Application no: **3/2022/0777**

Address: **Teewood Farm Barns Slaidburn Road Waddington BB7 3JJ**

The Local Highway Authority have viewed the plans and highway related documents and have the following comments to make:

Proposed Site Access

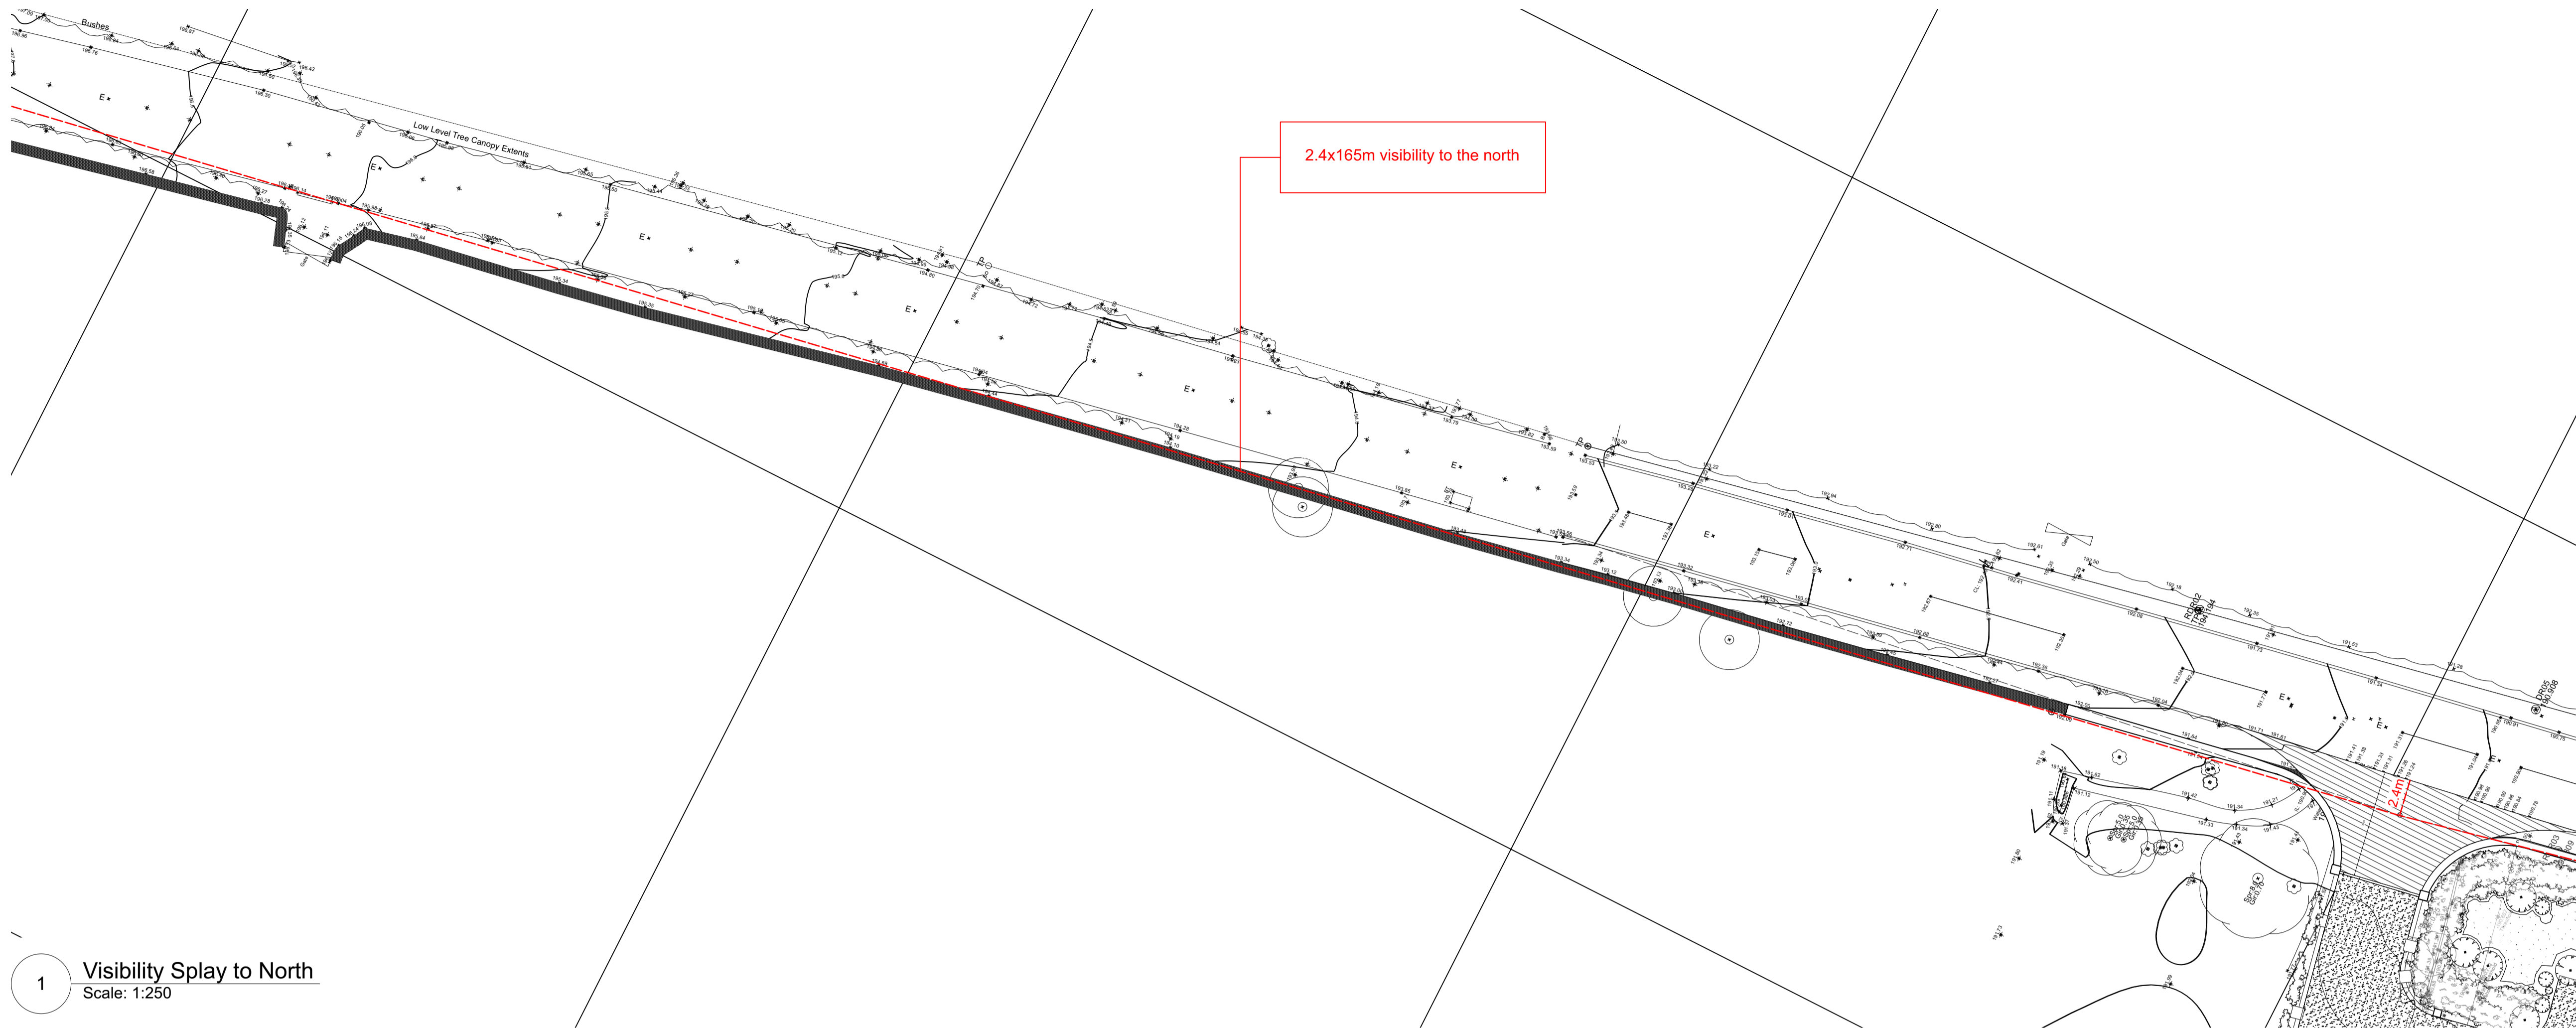
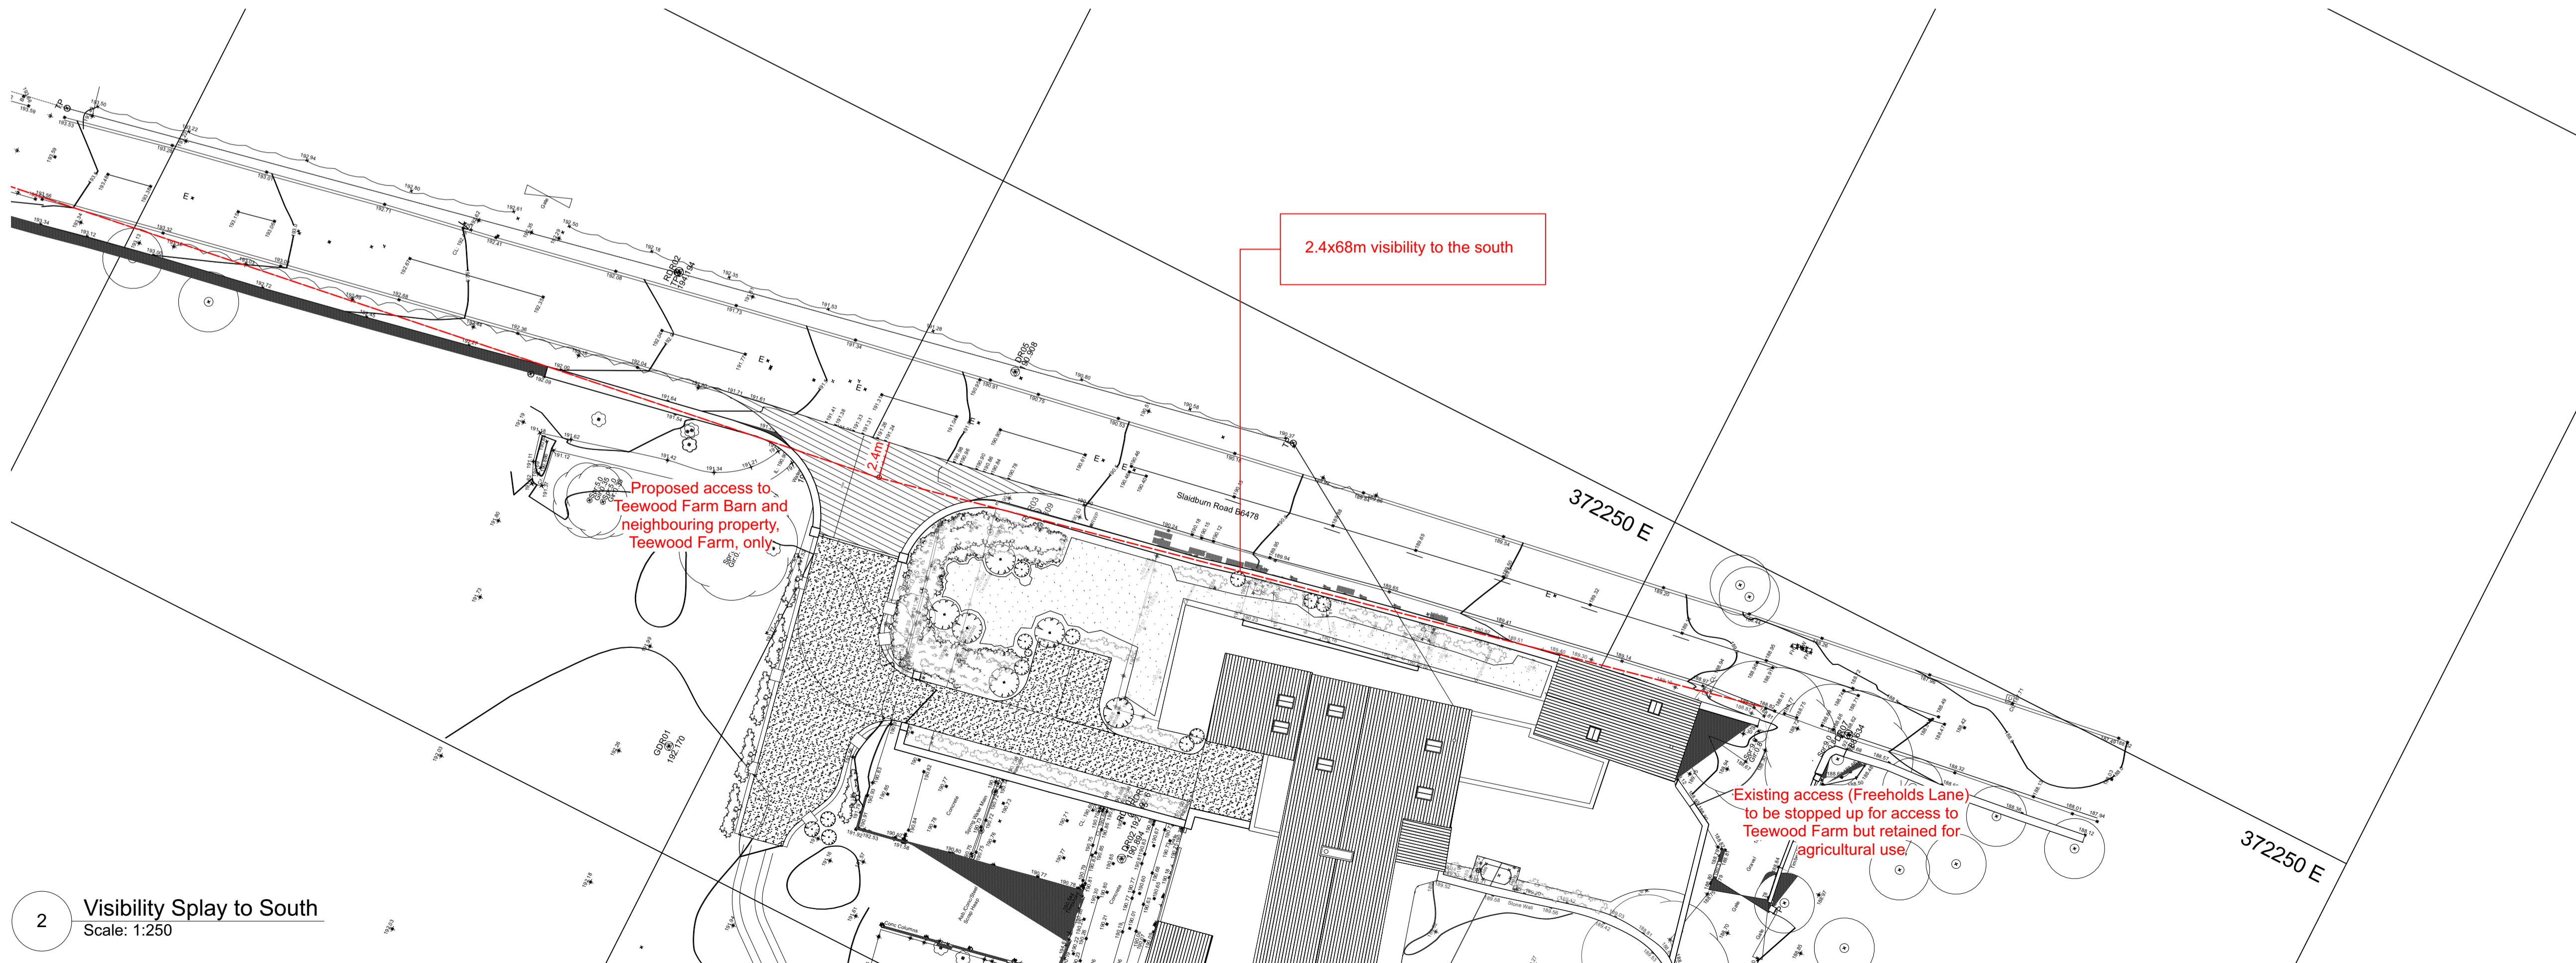
However, the LHA have reviewed Define drawing number 046_PLN_204 Rev A titled "Proposed Site Access" and are aware that the site access can only provide visibility splays of 2.4m x 165m to the left and 2.4m x 68m to the right of the access. This does not comply with the LHAs guidance for a 60mph road, with the LHA requiring visibility splays of 2.4m x 214m in both directions.

Despite the shortfall in both directions, the LHA will accept the shortfall in visibility. This is because the existing access, which is located off Freeholds Lane, has minimal visibility due to the location of the existing outbuilding to the left and the vegetation and curvature along the adopted highway to the right of the access. Therefore, while the proposed access does not comply with the LHAs guidance, the access is better in terms of highway safety than the existing due to the access being able to achieve more visibility. As a result, of this the LHA will accept the shortfall and will have no objection to the creation of a new access.
